Submission - Lane Cove West Data Centre - SSD-9741

I am a resident of Lane Cove and a long-standing member of Lane Cove Council's Bushland Management Advisory Committee. While I do not object to the location of a data centre in this area, per se, as it seems a land use compatible with the surrounding area, this proposal is unsuitable for this site and I would like to register objections to the existing proposal on several important grounds:

Drawing Title
VISUAL IMPACT VIEW POINT LOCATION

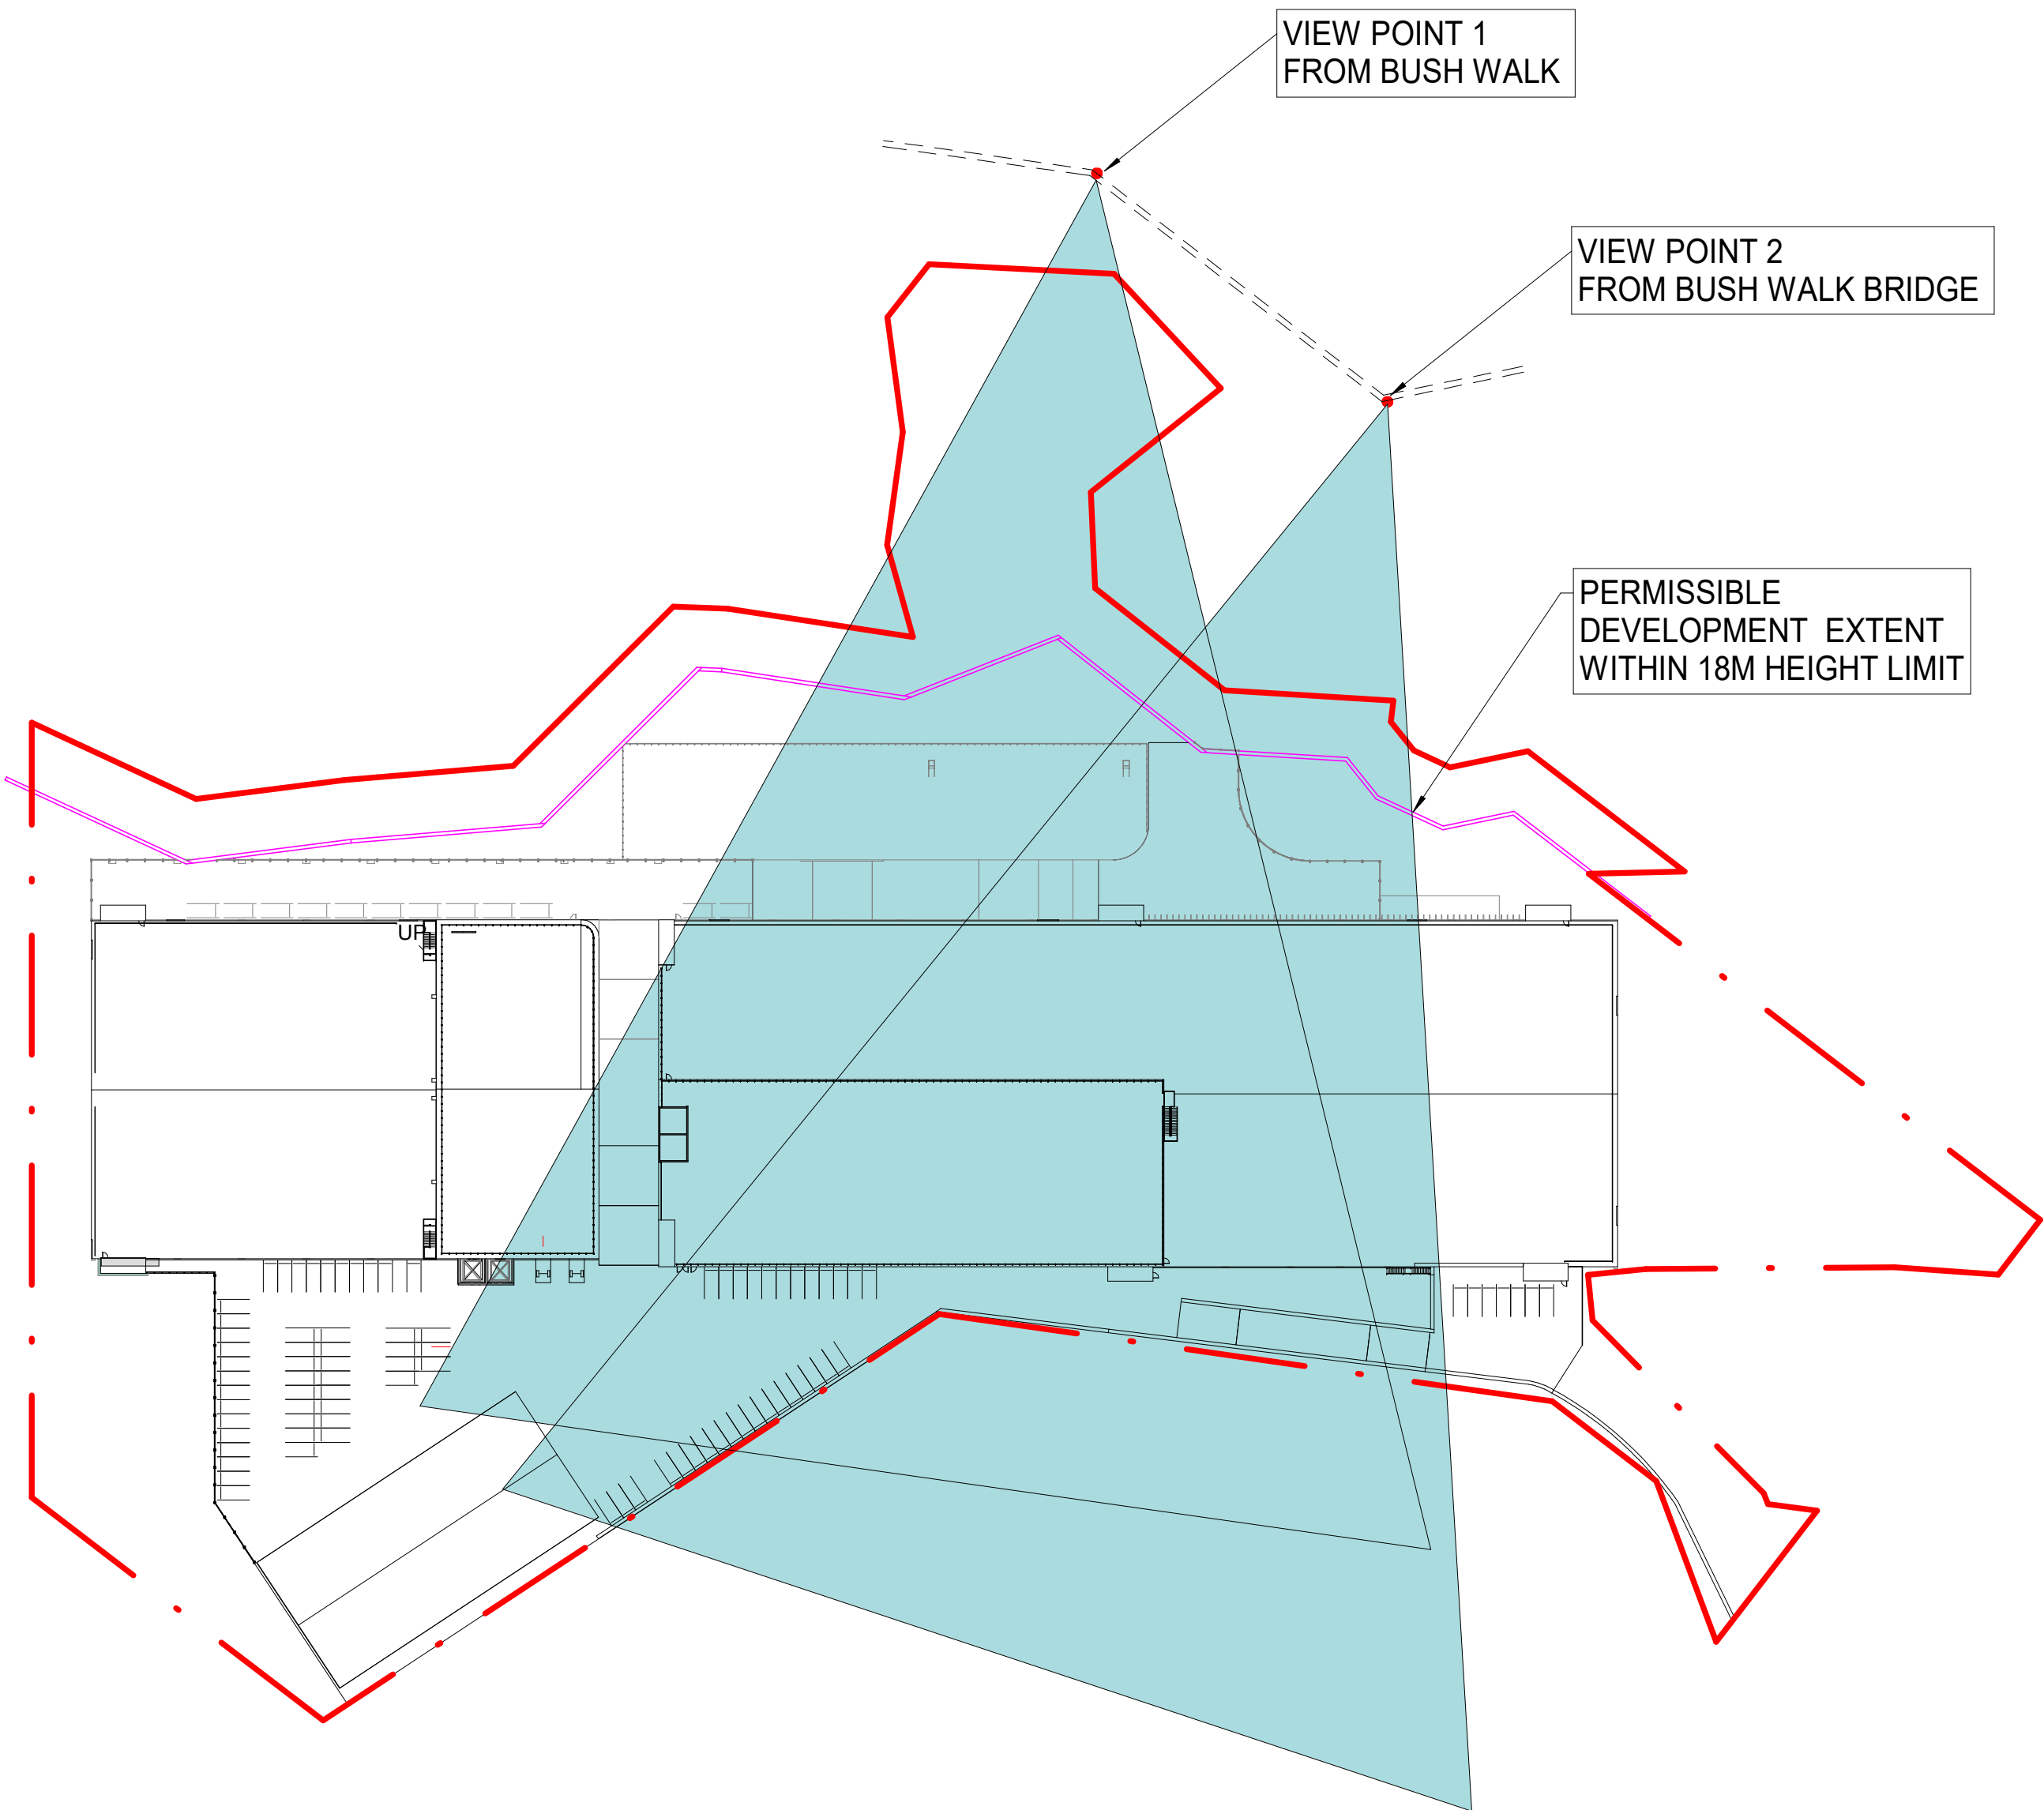
This is a massive building development for this location. The landscape context for this development is not predominantly the industrial zone on the eastern side, in part because the site sits at the end of its own entrance drive and does not present a main street frontage. Rather its landscape context is the view from the west as shown in the photo montage on page 1 of Appendix 5, the Architectural Plans.

The Lane Cove River upstream of Figtree Bridge at Hunters Hill presents a very 'natural' character, a corridor of vegetated slopes punctuated by very few buildings. Such a corridor is highly valuable in an inner urban context. The river is used by many canoeists/kayakers, there are walking tracks on both sides of the river and the river corridor provides a peaceful natural experience close to the many people who live in surrounding areas. This building would be highly intrusive in this landscape. As it sits on a site lower and closer to the river and the vegetation corridor than the rest of the industrial area, it should be far more sympathetic to that environment in its design.

Drawing Title
18 HEIGHT DIAGRAM

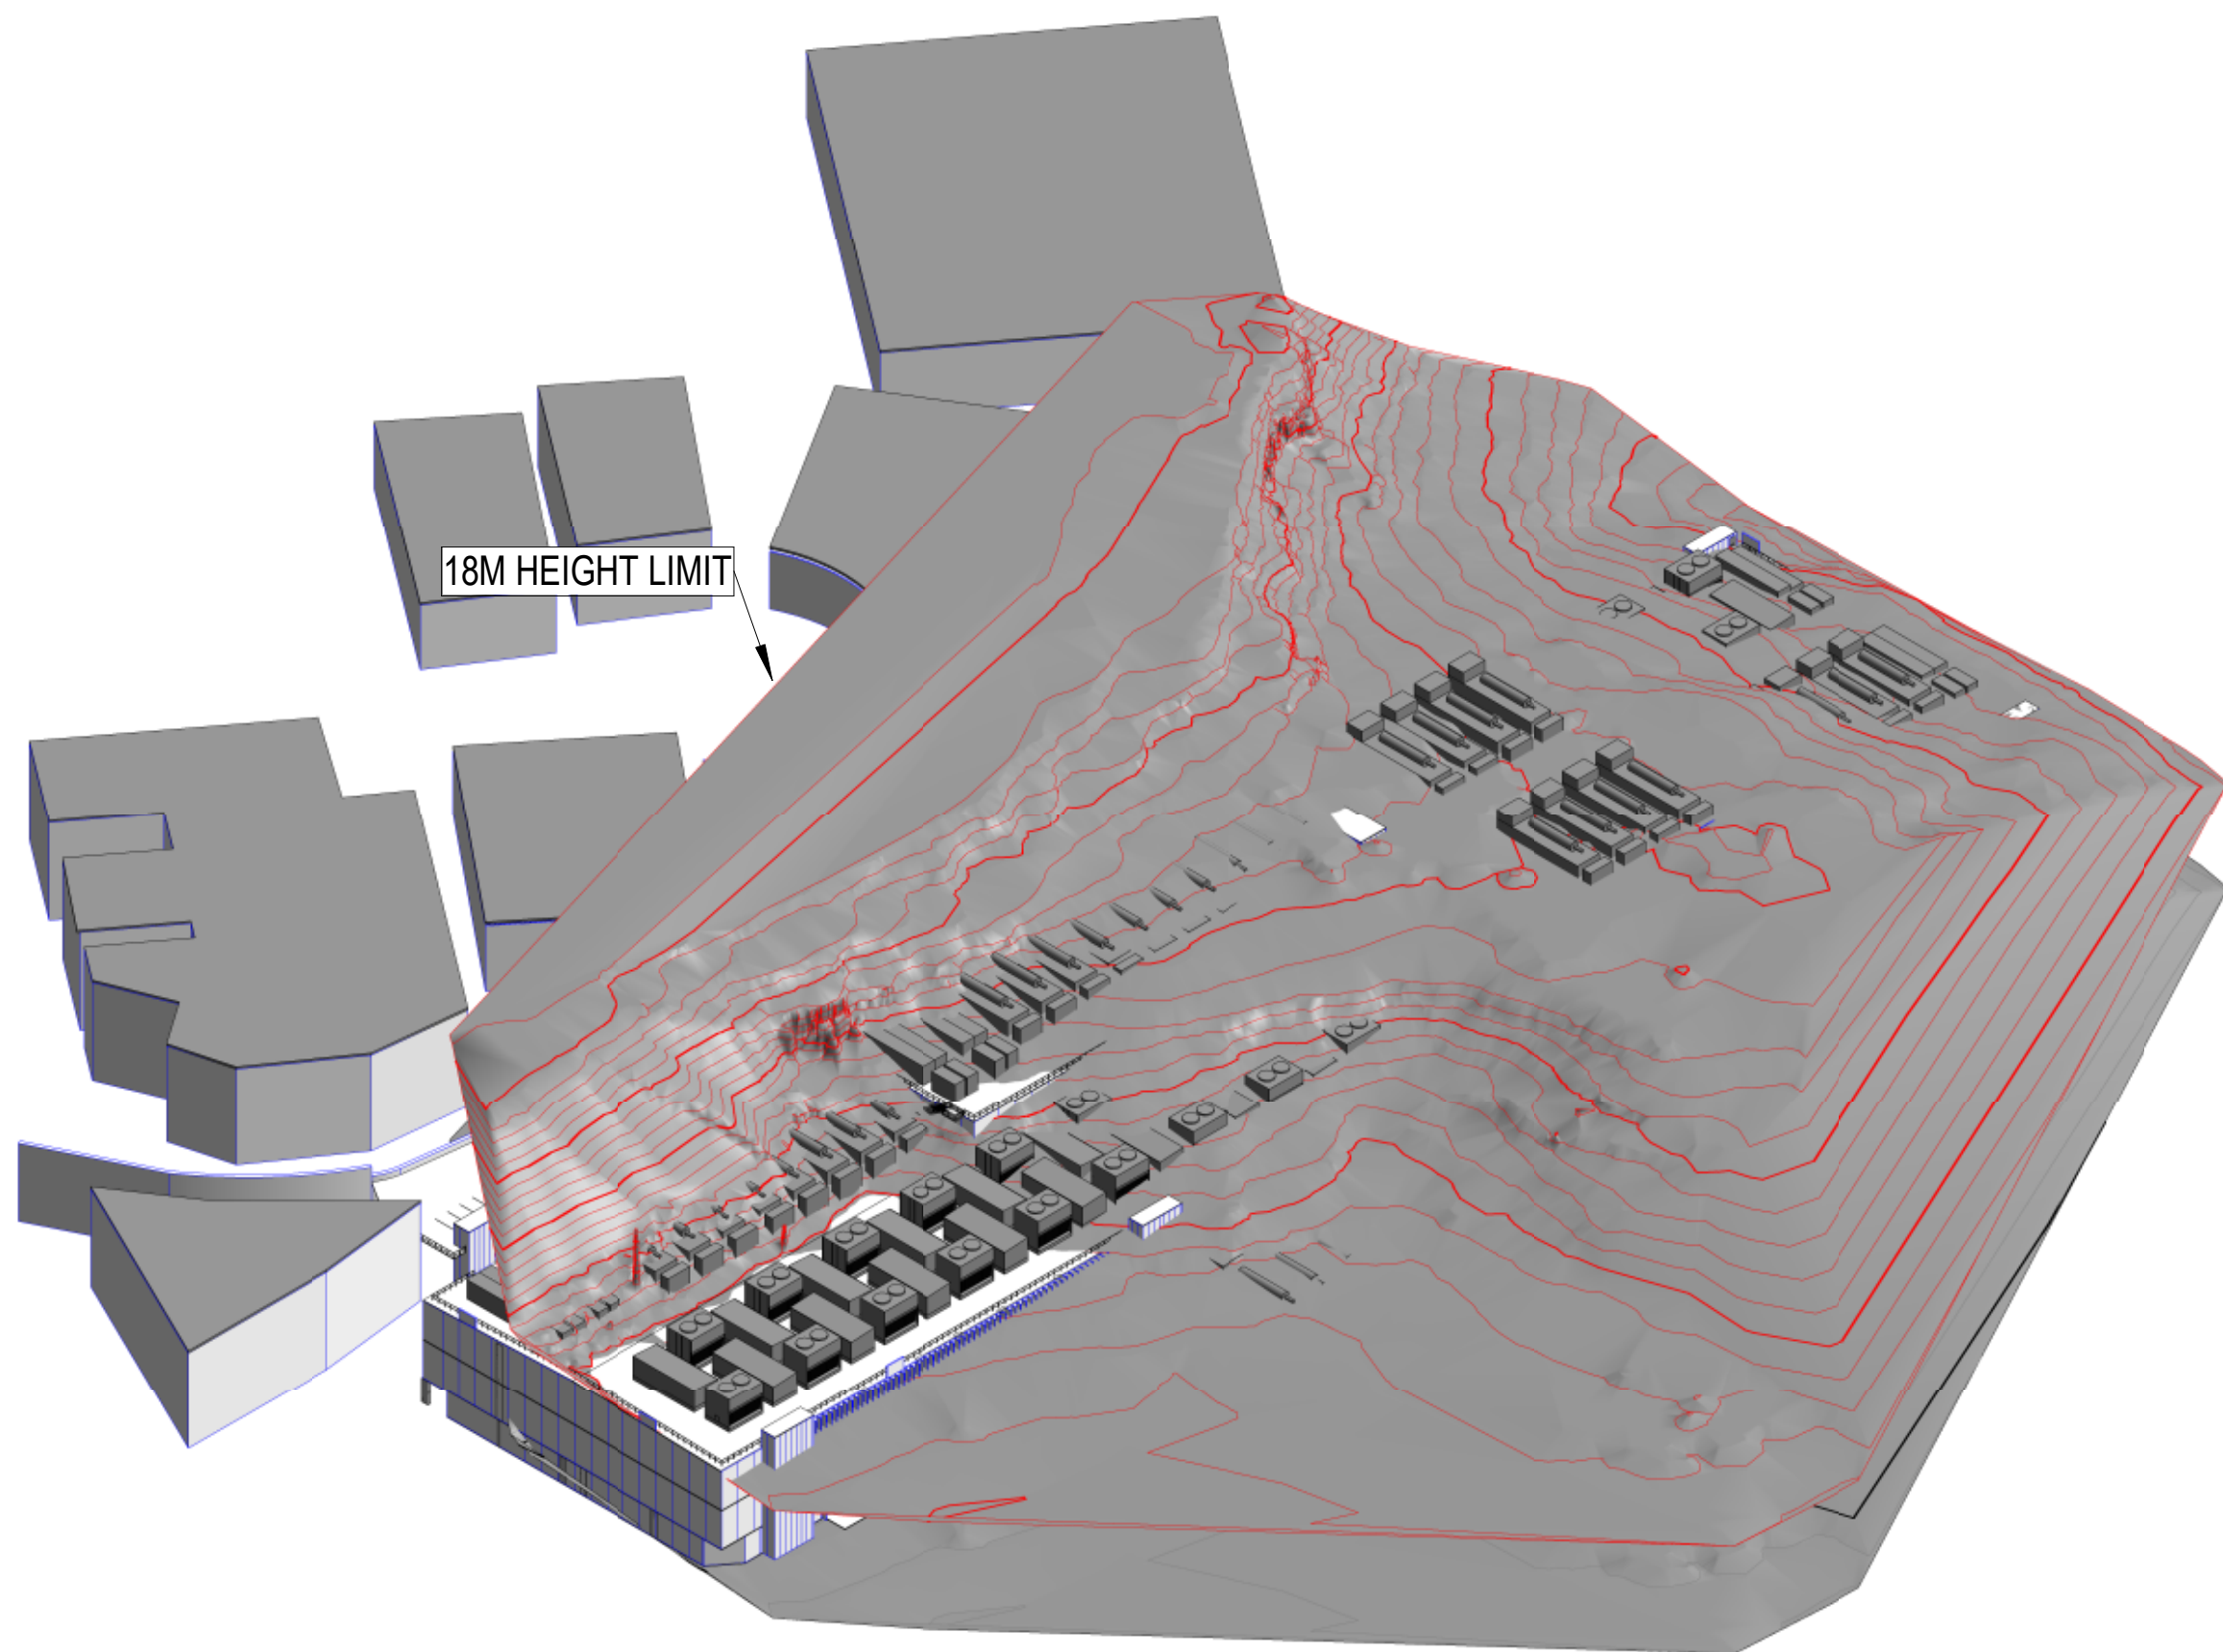
Yet, not only do these buildings occupy as big a footprint as possible on an unevenly shaped site with a section of contaminated land that cannot be developed, the buildings exceed the maximum height allowed under Lane Cove's LEP 2009 by 6 metres (as identified in Table 8 of the Environmental Impact Statement). And this is the case across the whole development, which is essentially a big rectangular box. The application for variation (Appendix 35) does not present any convincing arguments why this exceedance should be allowed, in fact it is quite confused/confusing at some points, arguing that the development maintains the LEP standard, except for exceeding it by 6m.

This proposal is unsuitable for this site - it is an overdevelopment of a sensitive site. It would impact local vegetation and wildlife through clearing of important local patches of native vegetation and loss of trees. It exceeds lane Cove's LEP maximum height for this area by 6 metres and its bulk and height are too great for its landscape context in a sensitive river corridor, while the impacts of a cut and fill construction are likely to be unacceptably high.
